Rezoning Transportation Analysis

Petition Number: 2020-120

Revision Log:

Date	Description
09-11-20	First Review
10-19-20	Second Review
11-30-20	Third Review (EL)
12-28-20	Fourth Review (EL)
01-26-21	Fifth Review (EL)

REZONING PLAN
RZ.01

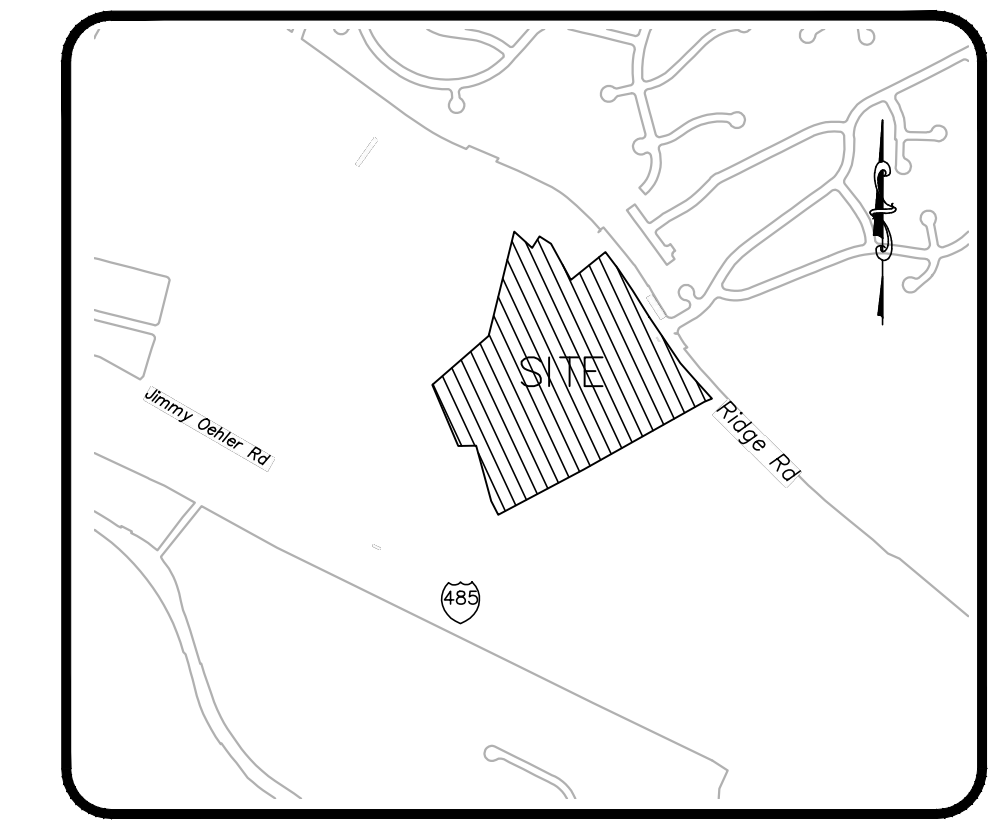
8. **Outstanding Comment (site plan dated 10.12.2020):** The petitioner should revise the site plan and conditional note(s) to update the proposed curb line, 8-ft planting strip, and 12-ft multi-use path, according to the redlines shown below. After additional review of the approved plans for **SDRMFR-2019-00041 - Redwood Ridge Road**, the development is providing an 11-ft center turn lane, as opposed to the 10-ft center turn lane that was recommended within the Prosperity Hucks Area Plan. **This three-lane section should be provided along the entire property frontage along Ridge Road.**

- a. **Technical Clarification (site plan dated 12.14.2020):** Revise the site plan and conditional note (**Section C.5**) to confirm that a three (11-foot) lane section will be constructed according to CDOT standards, along the entire property frontage of Ridge Road. The updated site plan indicates widening, but a consistent three (11-foot) lane road section needs to be provided along the entire frontage. The current site plan proposes varying lane widths. This may be reviewed in detail during permitting, and the required widening will occur asymmetrically.

9. ~~Outstanding Comment (site plan dated 10.12.2020):~~ The petitioner should revise the site plan to accommodate a private driveway designated for the future solid waste and recycling center, that allows space for all garbage truck turning movements to occur within the private drive, without maneuvering within the public right-of-way. Please provide site plan note stating that garbage truck turning movements will occur outside of public right-of-way.
